WEST SUSSEX COUNTY COUNCIL CONSULTATION

TO:	Arun District Council
FROM:	WSCC Highways - Public Rights of Way
DATE:	10 April 2026
LOCATION:	Land off Arundel Road Fontwell
SUBJECT:	WA/18/26/PL Erection of 64 residential dwellings with access off Arundel Road, together with associated parking, open space, play space, landscaping, drainage and infrastructure. This application is a Departure from the Development Plan, affects a Public Right of Way, may affect the setting of listed buildings and is in CIL Zone 3 and is CIL Liable as new dwellings.
DATE OF SITE VISIT:	n/a
RELEVANT PUBLIC RIGHTS OF WAY NUMBER(S):	2825
RECOMMENDATION:	Advice / No Objection
S106 CONTRIBUTION TOTAL:	Yes

FIGURE 2-2: PUBLIC RIGHTS OF WAY (COURTESY OF WSCC)

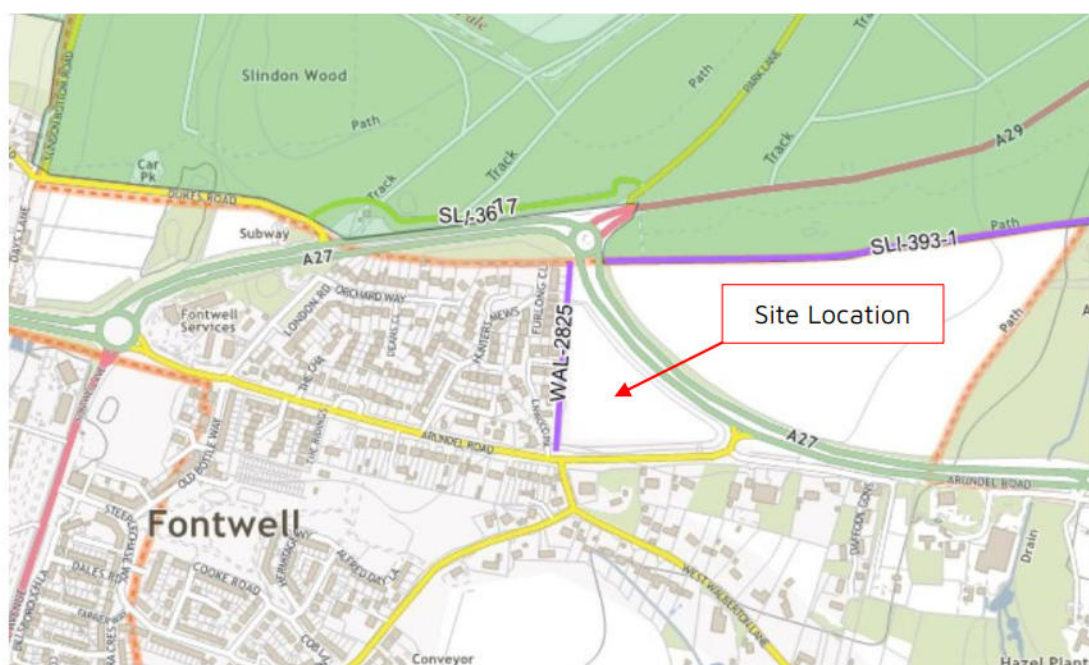
Footpath 2825 runs along the Western edge of the site and is presently on an unmade surface and narrowed in places due to encroaching side and overhead vegetation. I welcome the retention of this footpath on its present line and also the retaining of the natural 'corridor' of trees and vegetation which will screen the PRow from any future development to its East. As it already lies in an urban area with a new development underway to the West, the Footpath form an important link and additional access onto the development is sensible.

Due to its importance as a link both to the North and South of the site and inevitable increased use in the future I would ask that improvements be made to the Public Footpath, funded and carried out by the applicant and made a condition of any planning consent.

I would ask that a minimum 2m width be achieved and surfaced to WSCC PRow requirements. The surface will consist of a stone surface, compacted and cambered to shed rainfall; full specifications can be requested in due course. Some light clearance and overhead pruning will be required and should form part of any future maintenance programme as is the landowners' responsibilities with regards keeping Public Highways clear of vegetation.
